KITITAS COUNTY

MEMORANDUM

SUBJECT: LPF-22-00004 Suncadia Phase 2 Division 7 Final Plat Comments

APPROXIMATE LOCATION OF FEMA 1% ANNUAL CHANCE FLOODPLAIN (100-YEAR FLOODPLAIN) BOUNDARY AS PROVIDED BY KITITAS COUNTY IN JULY 2022

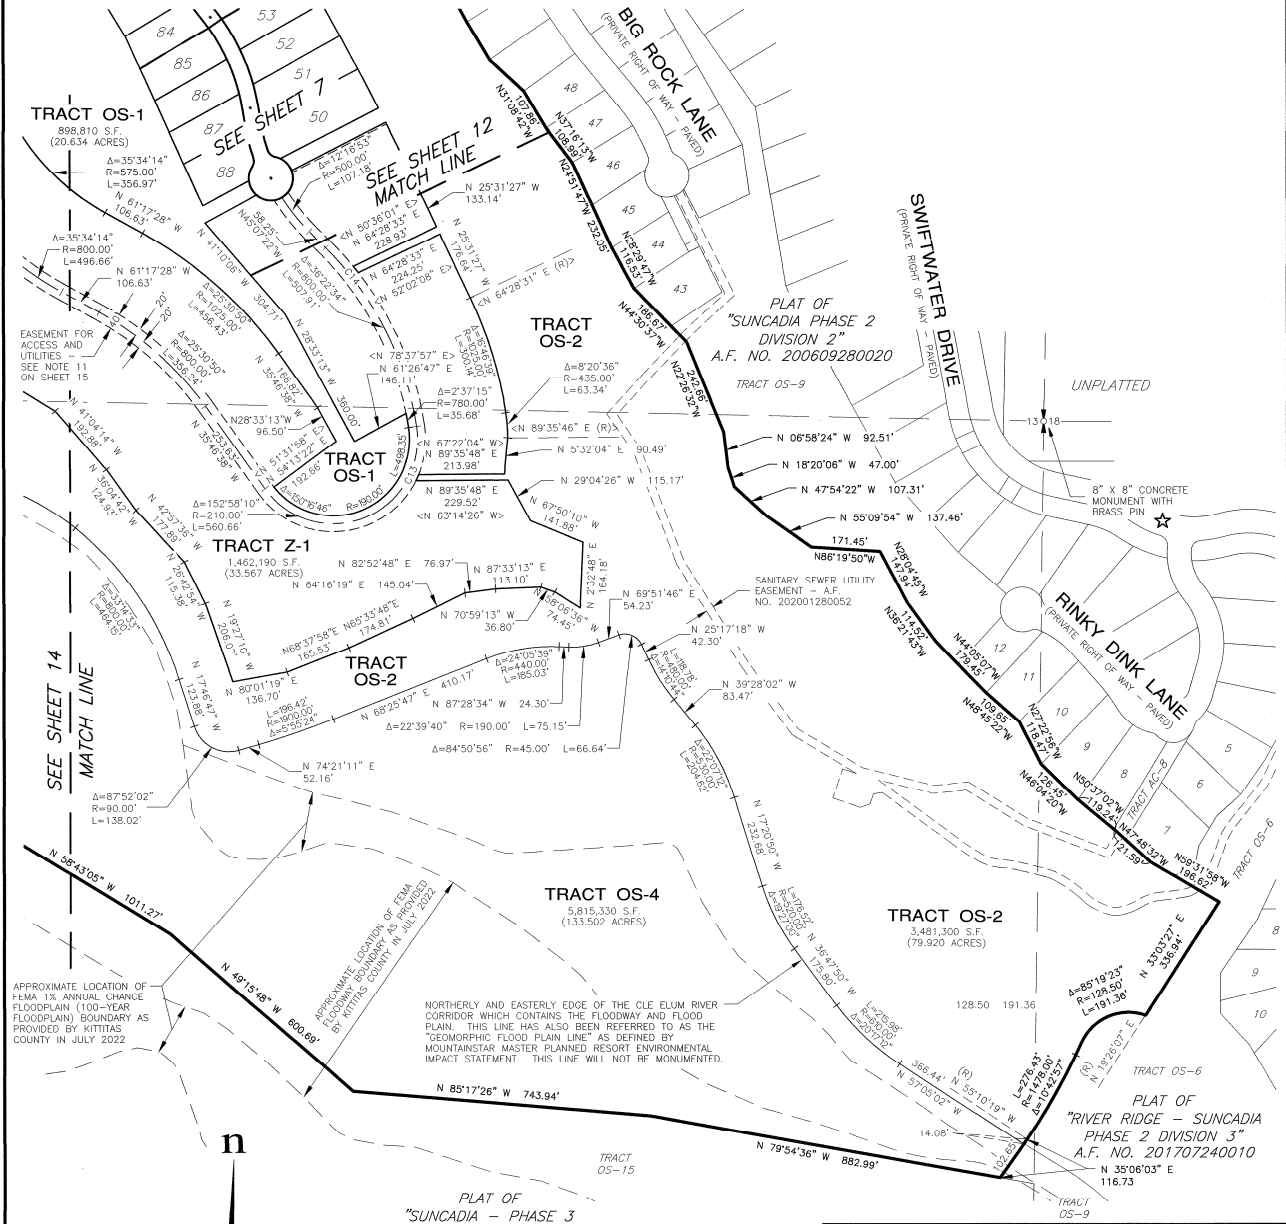
Since 12/7/1993, Kittitas County has required that all subdivisions show on the face of both the preliminary and final plat the boundary of the 100-year floodplain and floodway. Please see page 13 of the attached document. The numbering has changed but the subdivision requirements have not.

Floodplain development requirements for LPF-22-00004 have not been met. In accordance with KCC Chapter 14.08.220(5), all subdivisions shall show on the face of both the preliminary and final plat, for either short or long plats, the boundary of the 100-year floodplain and floodway.
